Permit Number: 080710

has permission to 1600 SqFt Single Family Home 3 Bedrooms.

AT 386 CAPISIC ST CBL 225 E010001

City of Portland, Maine - Building or Use Permit Application

Drawing file: PDF 080710 / capisic st plan.pdf

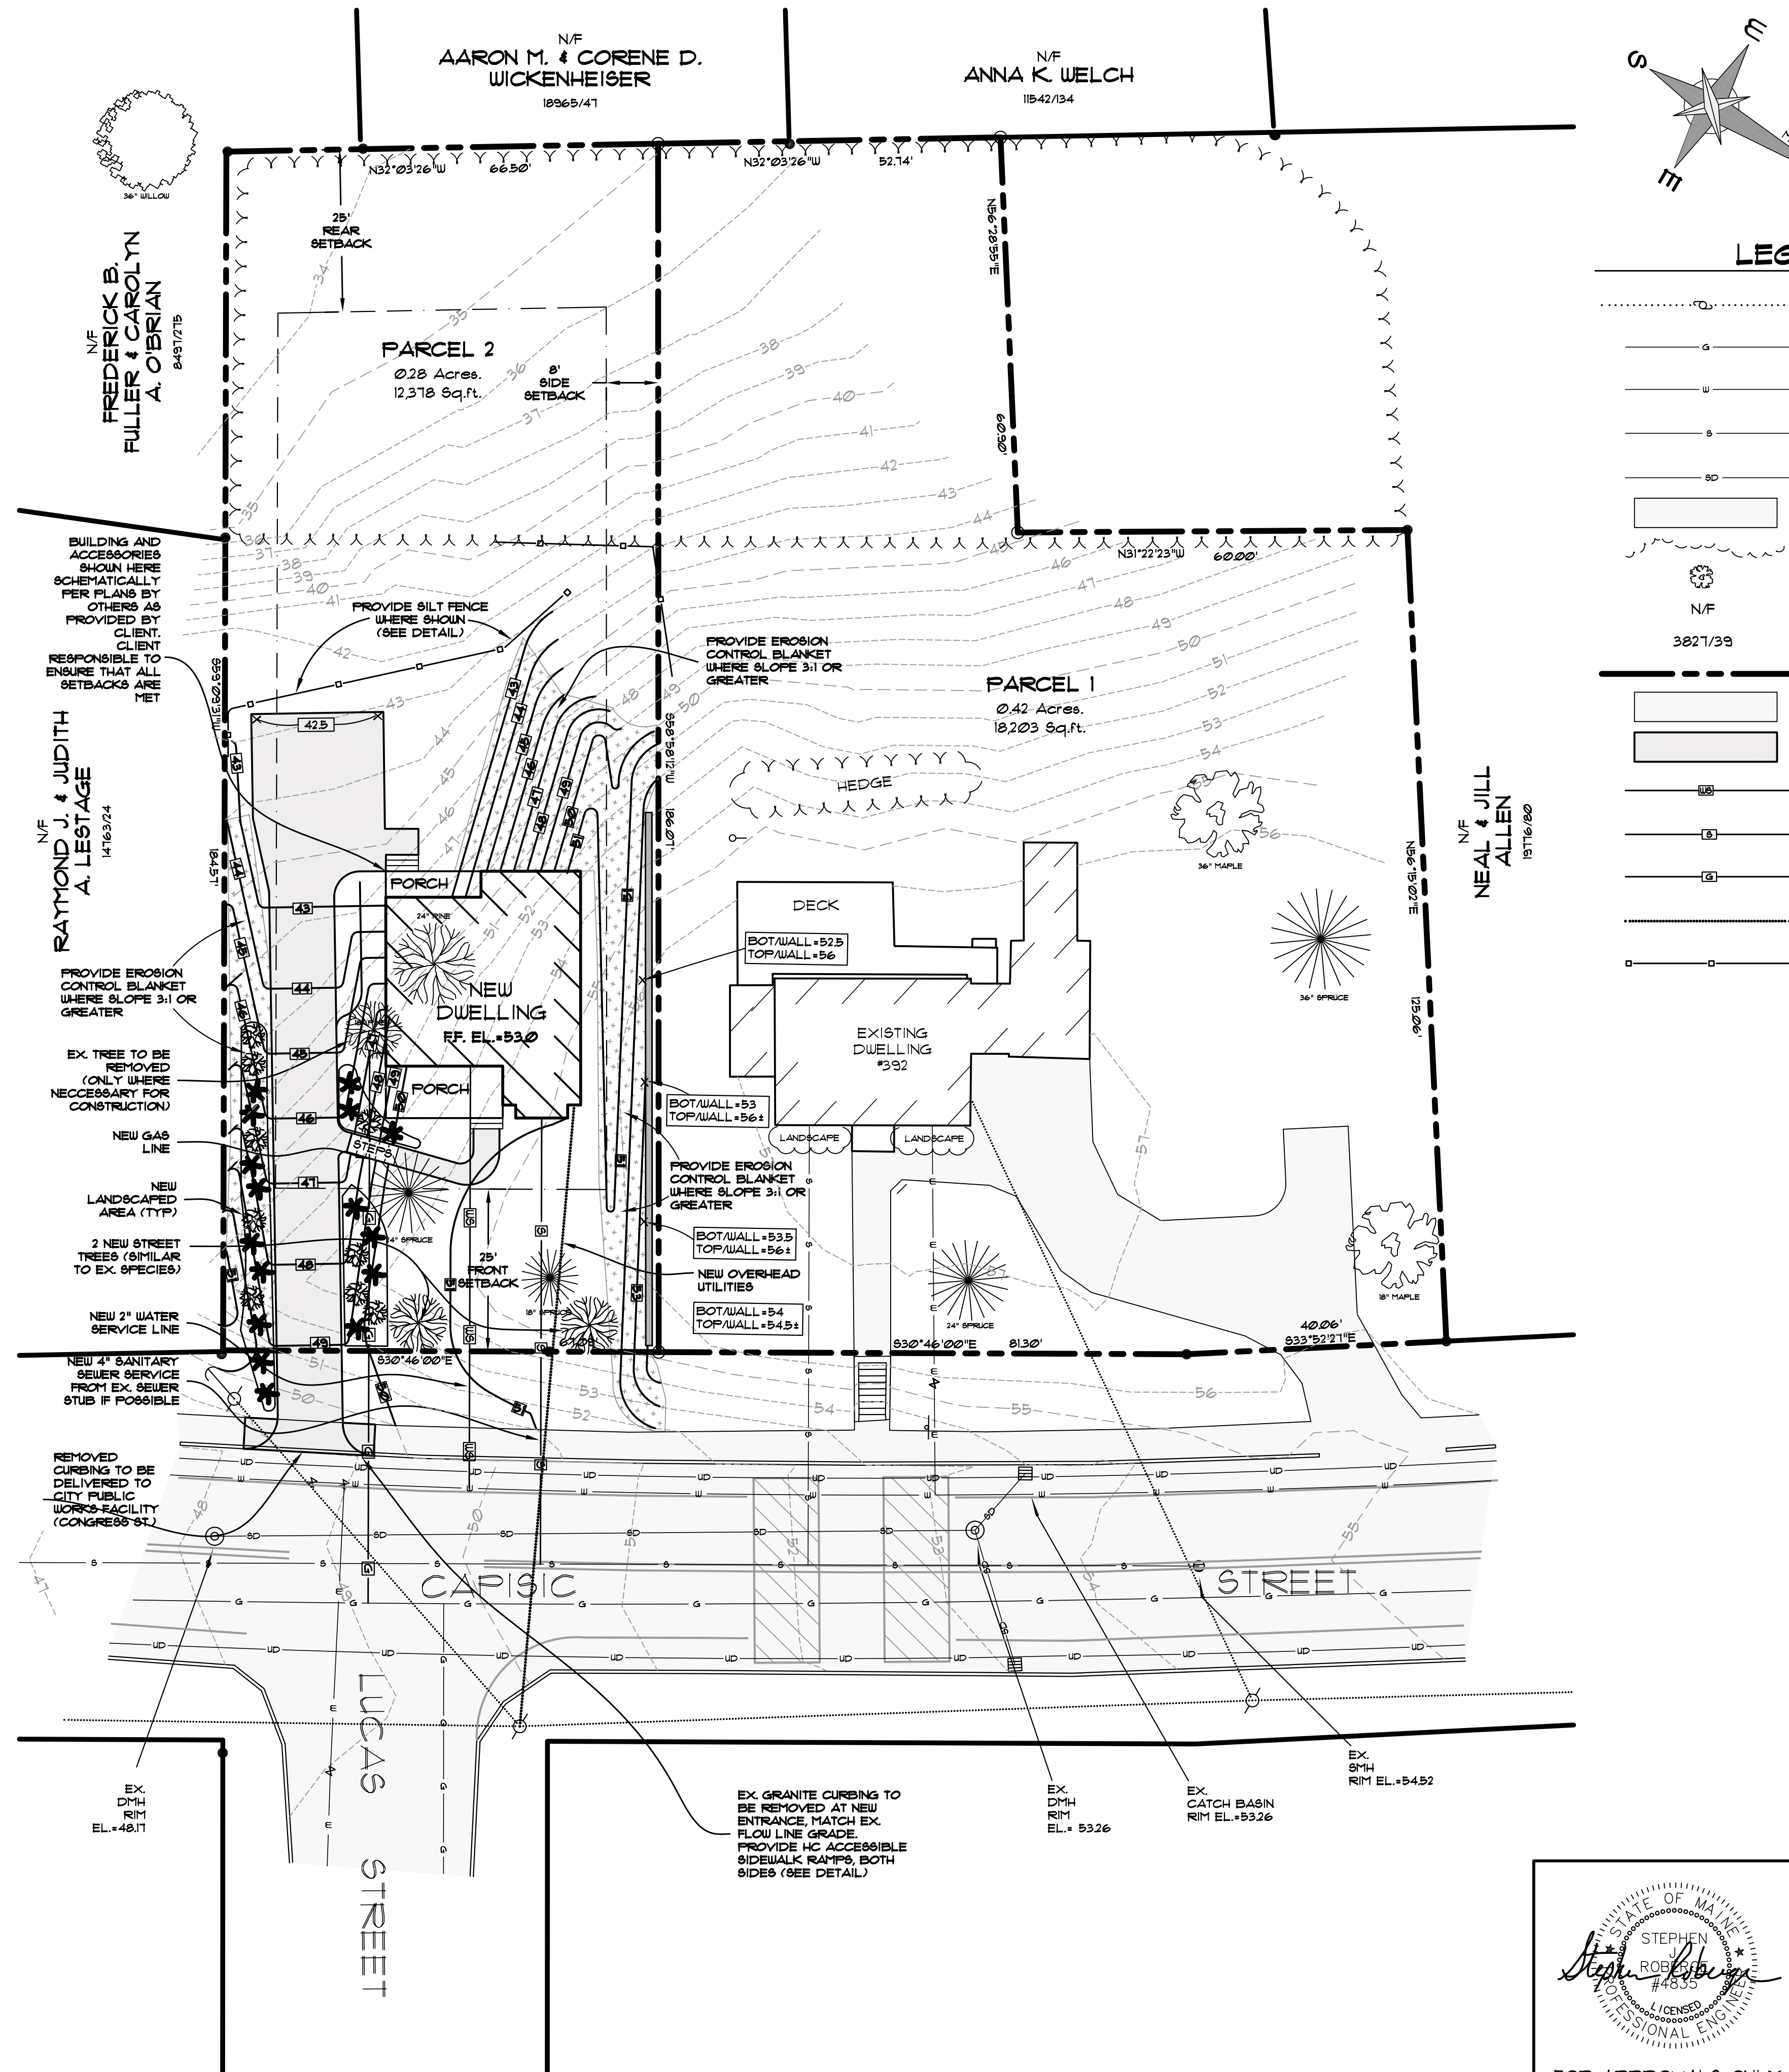
Comments:
6/23/2008-amachado: Spoke to Jim Gray. Need a full size copy of the siteplan that is scalable.
6/24/2008-amachado: Spoke to Jim Gray. Full size elevation plans don't reflect the grade change on the property. A daylight basement door is shown on the reduced building plans but not on the fullsize. Need details of the door and details on the foundation plan.
6/26/2009-amachado: Application was never complete. Jim Gray submitted a new single family application 6/22/09.
